CITY OF PORTLAND, MAINE
PLANNING BOARD

June 10, 2008

RE: Portland Museum of Art Parking Lot, 87 Spring Street, Portland
CBL: 039 B015 001
Application ID: 2008-0038

4 BIORETENTION CELL  
NOT TO SCALE

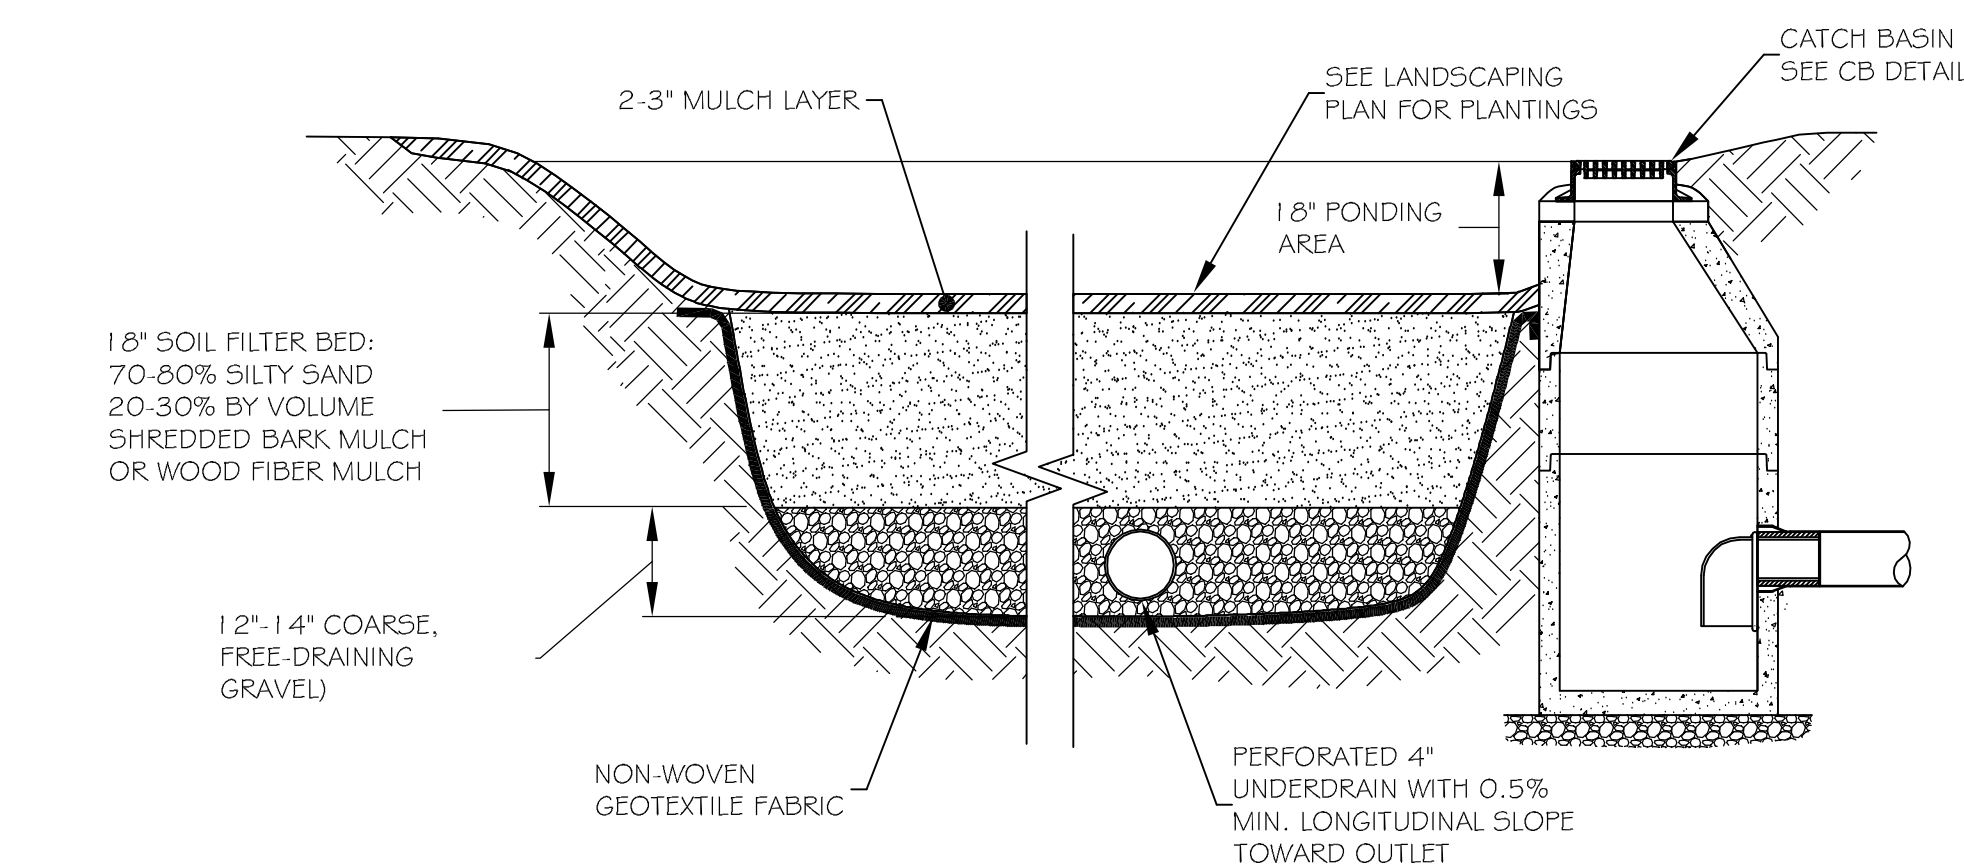
- ii. That the applicant shall be responsible for ongoing maintenance and monitoring of the operation of the biodetention cell/raingarden, and immediately address any problems that may arise (eg re survival of plantings, safety for the public), whether identified by the applicant or other parties, to the satisfaction of the Planning Authority; and
